SEVEN LAKES ENGINEERING SERVICES, INC.

Subject: Structural Assessment
21 Brewster Ct.
Cameron, NC 28326

Seven Lakes Engineering Services, Inc. (SLES) performed an inspection of the subject property on October 13, 2022. The purpose of this inspection was to assess the load bearing wall which is lacking a lug footer. The lug footer is a reinforced footing which is designed to carry the load of the second story floor system.

SHEET TITLE:
FOUNDATION

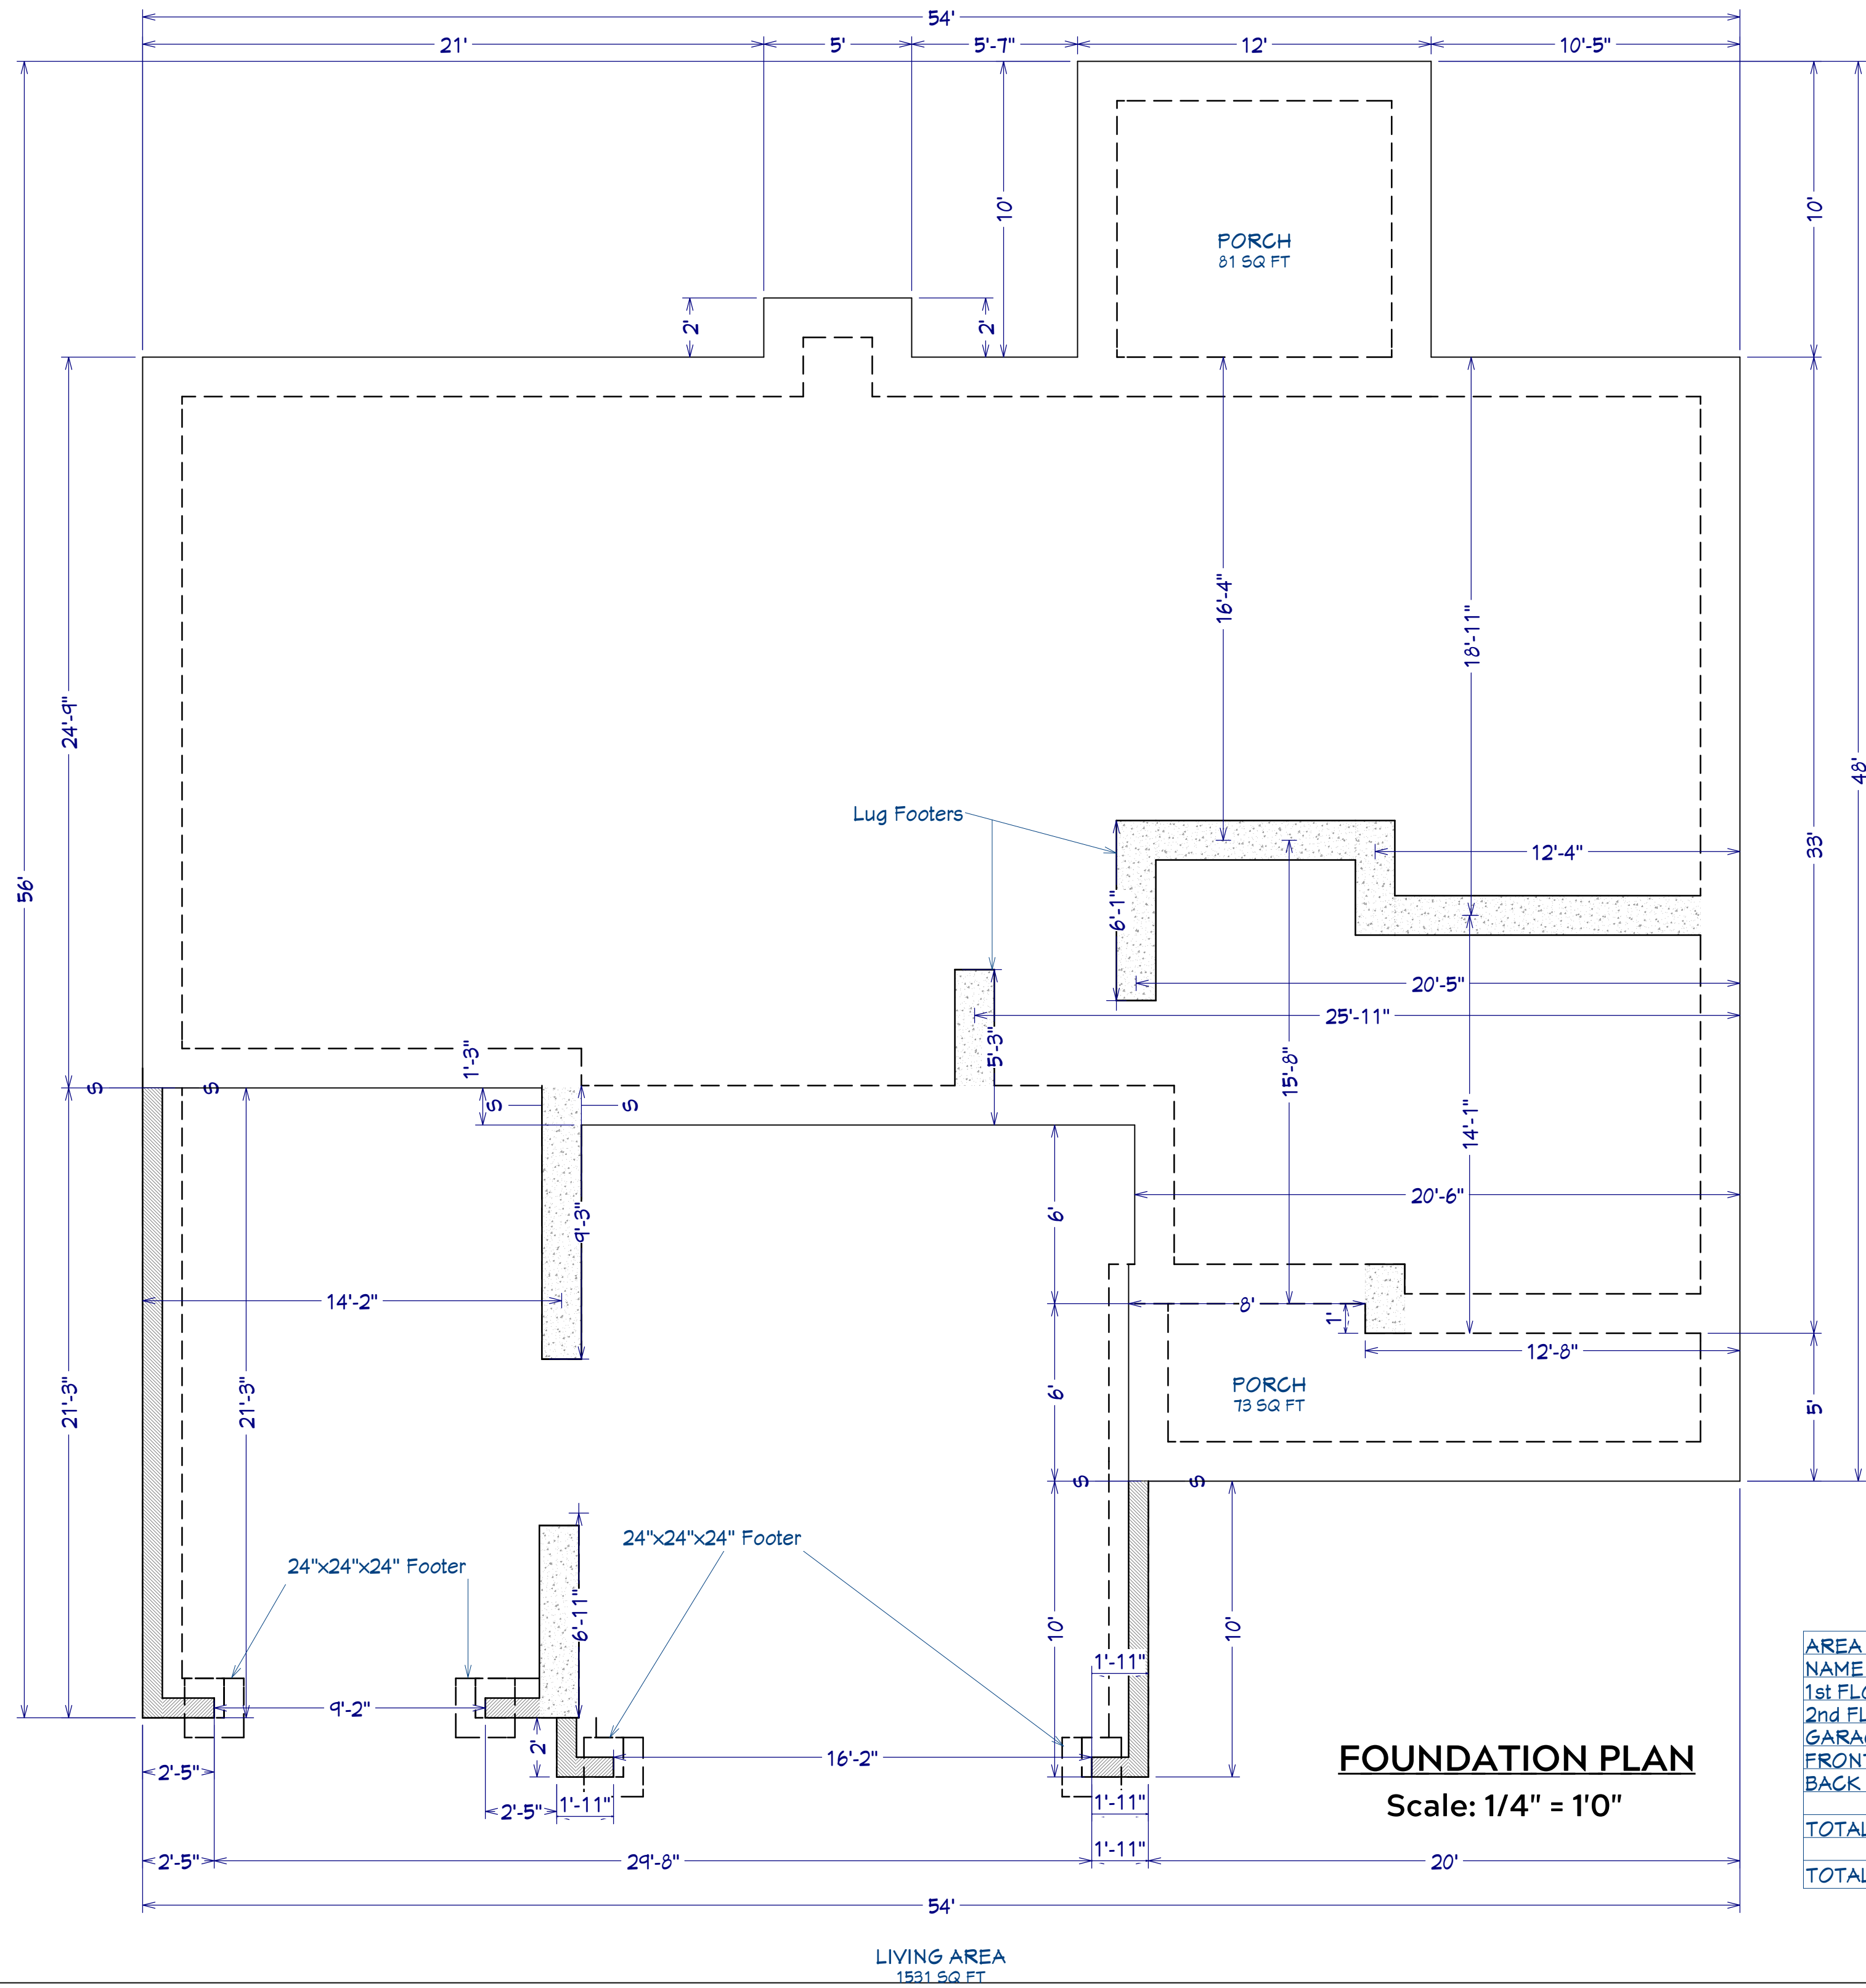
Upon inspection of the subject home, SLES noted that the interior load bearing wall between the great room and the bedroom on the first floor is missing a lug footer. The reinforced lug footer is designed to carry the load of the second story floor system. SLES also noted that the sill plate located in the garage is not sitting properly on the concrete slab.

SLES recommends that the second story floor be temporarily supported in order to cut a section of the concrete slab out for the installation of the proposed footer. Please refer to the attached drawing for more details. SLES also recommends that additional concrete be poured in the garage underneath the sill plate in question. Upon addressing both of these items, SLES will certify the repairs.
